ENG-SF21026-R3-FDR.pdf Markup Summary

Existing condition calculations need to be updated based on current criteria. See redlines in appendix.

NORTH POND NORTH FOREBAY
SCALE: 1"=10'

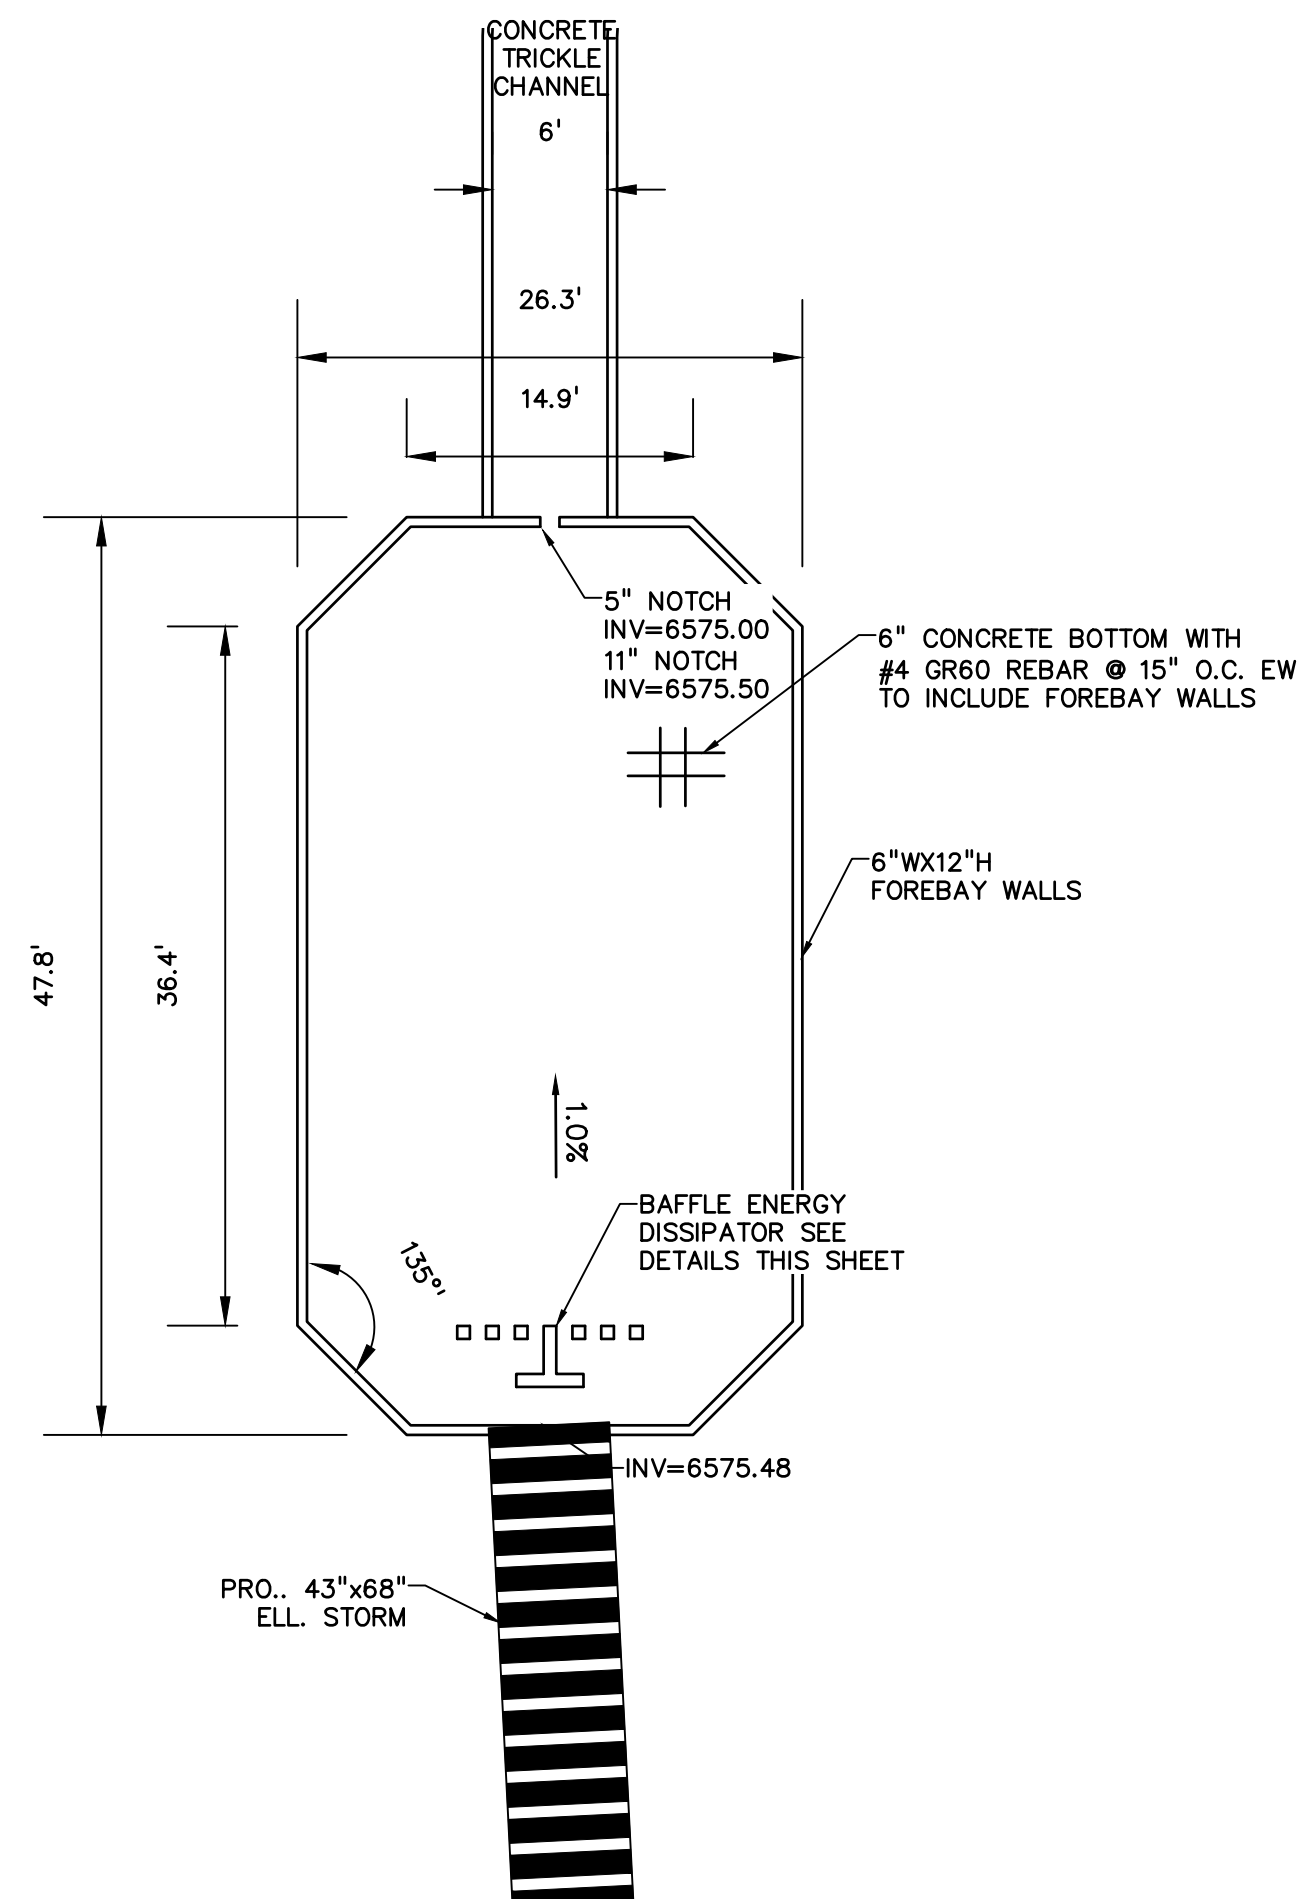
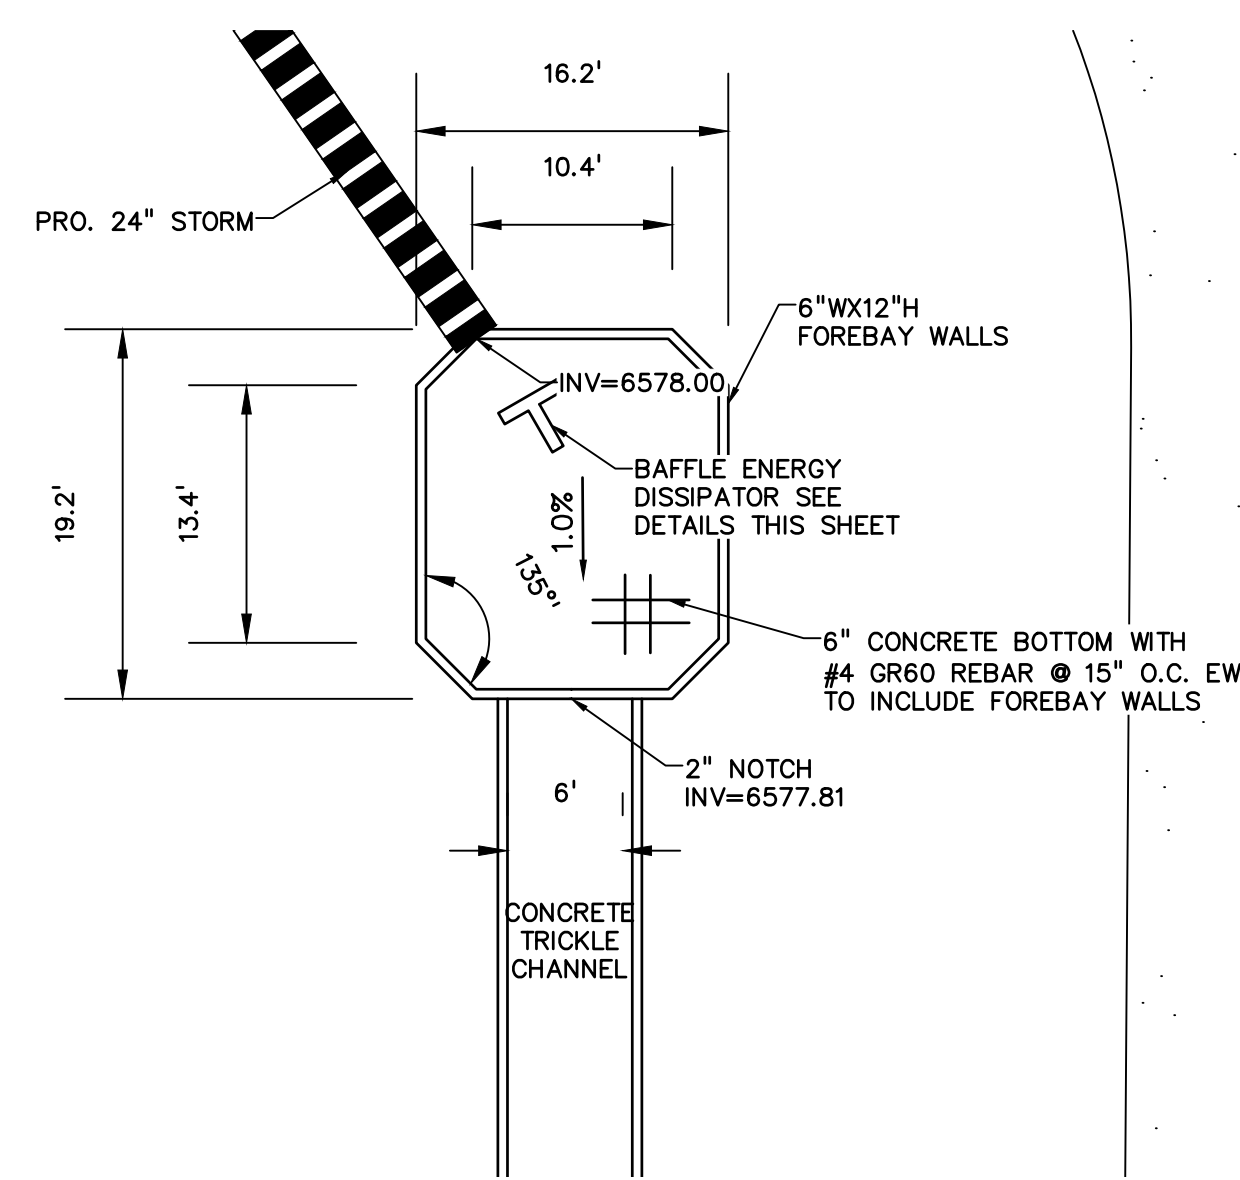
Each forebay should be designed per area directed to it.

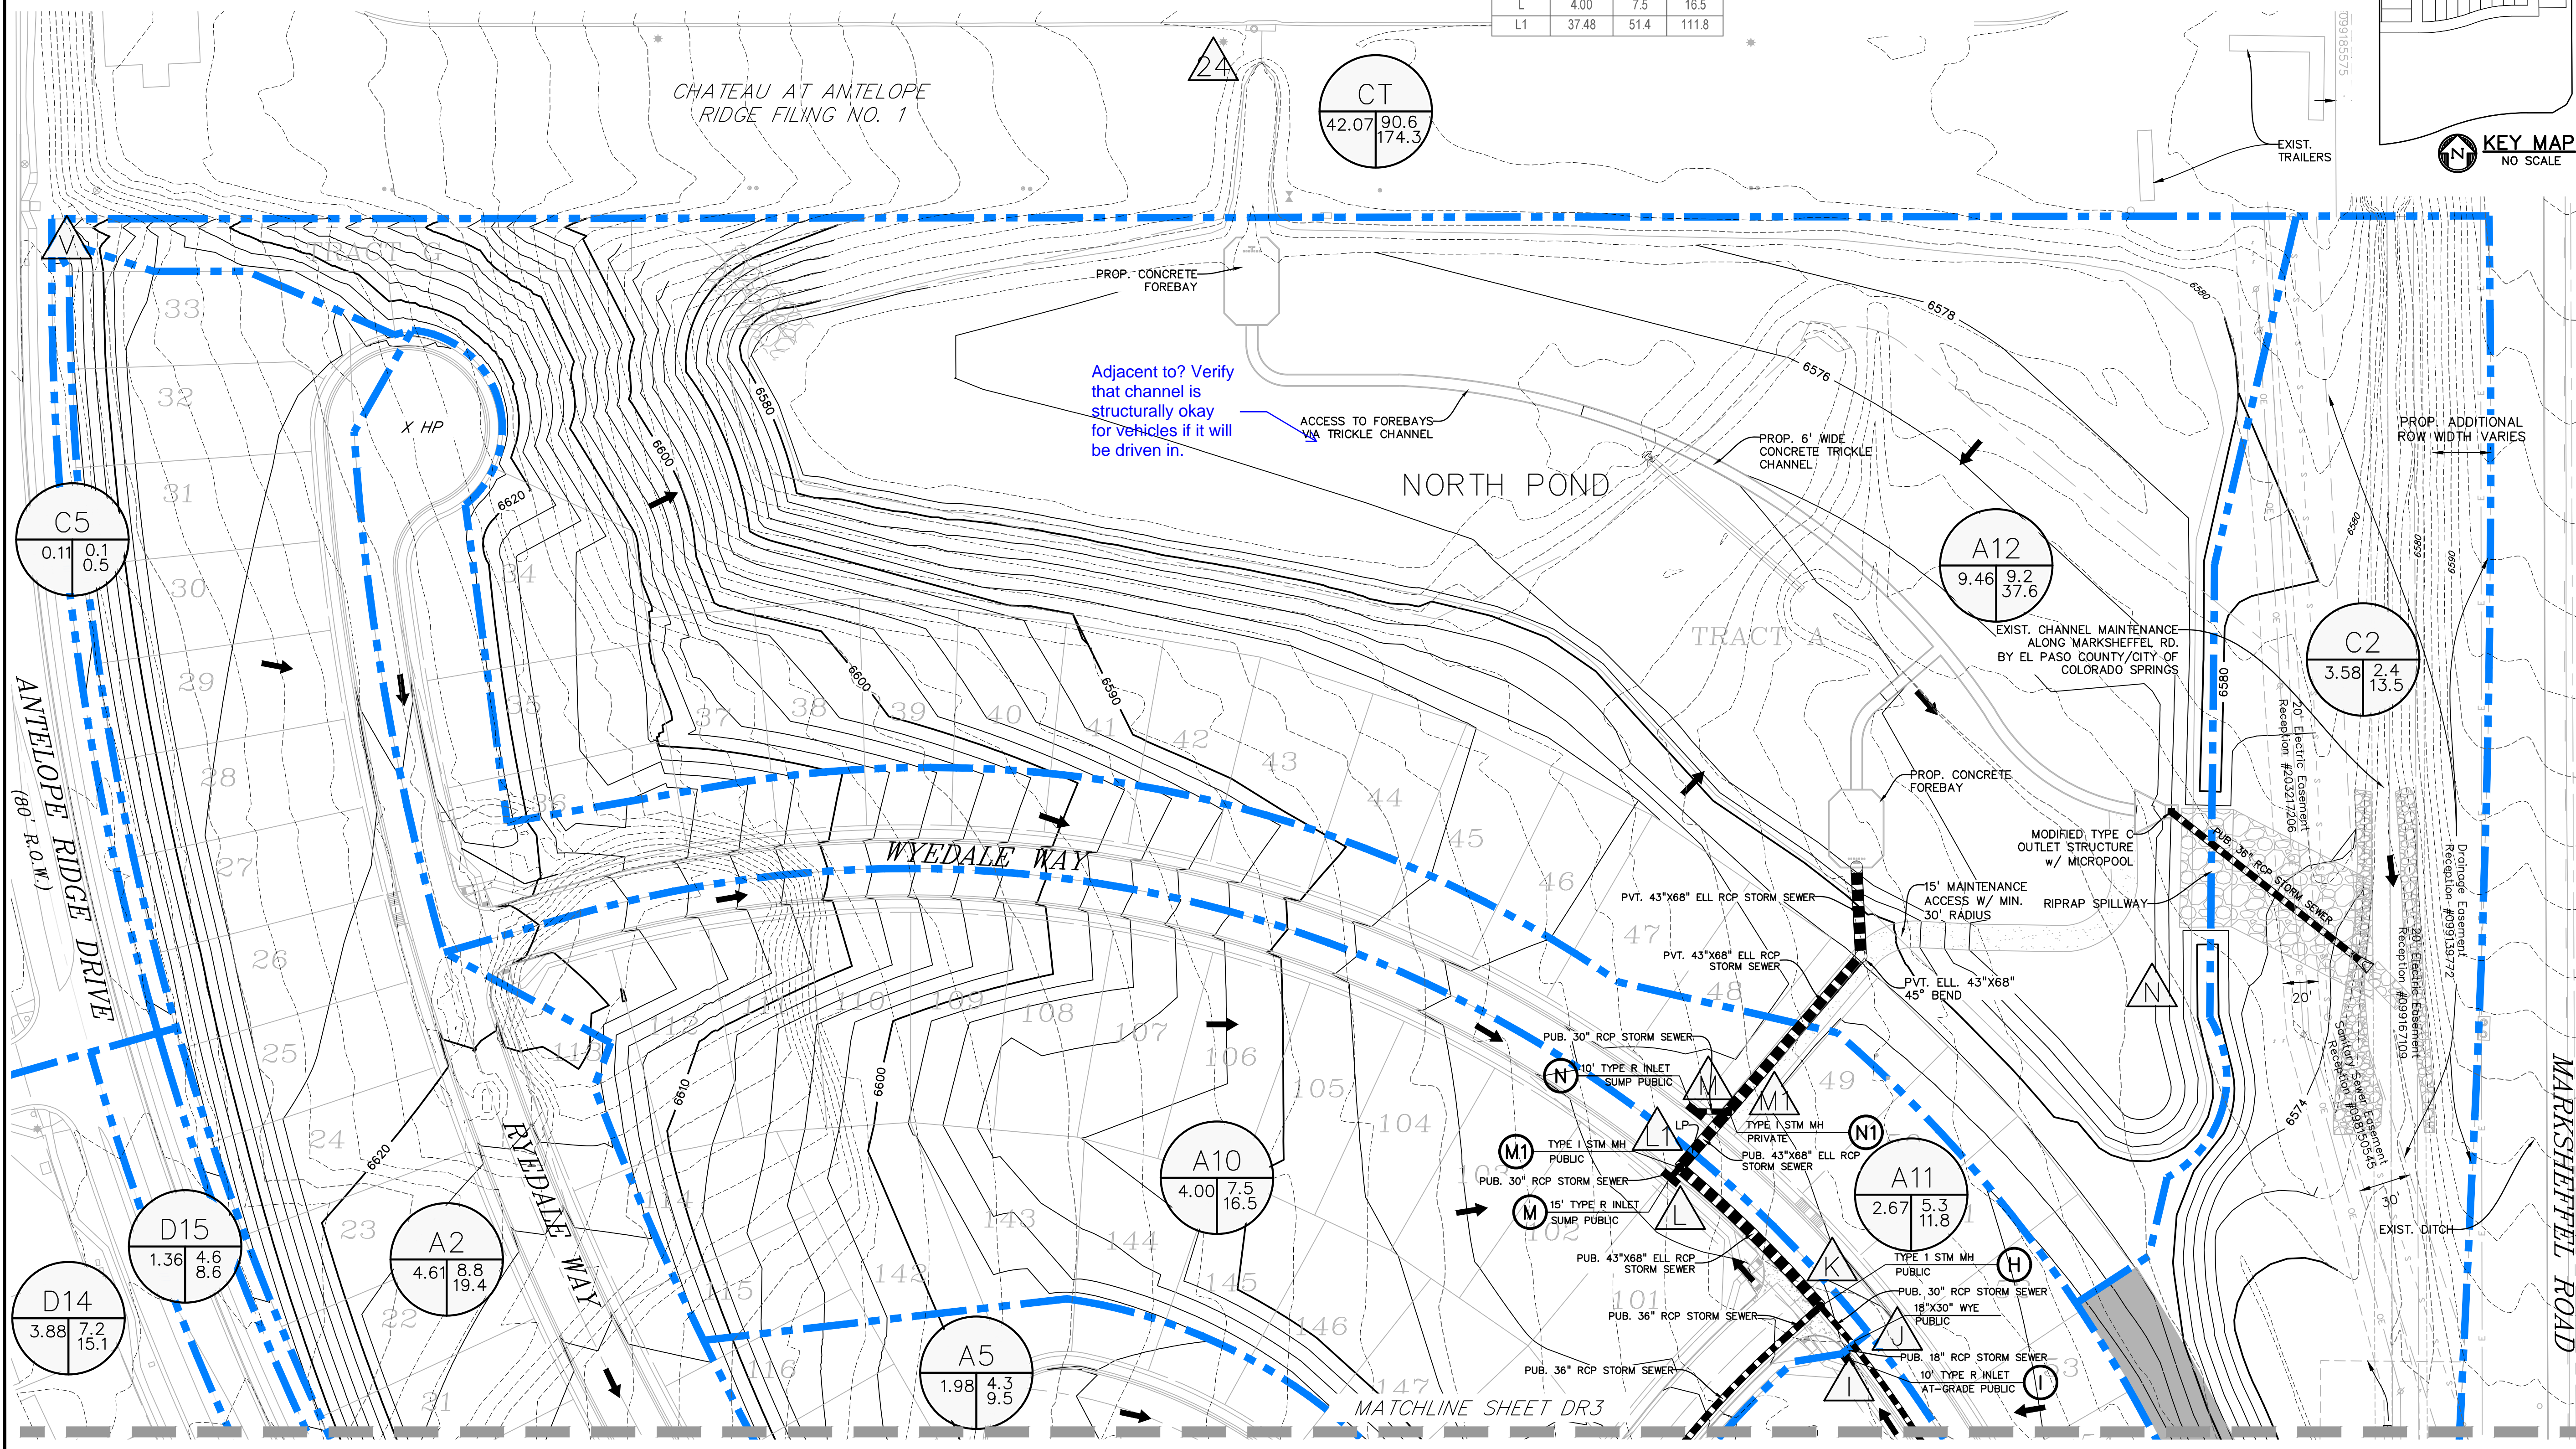
DP Table on Drainage plan shows area as 434.39 acres.
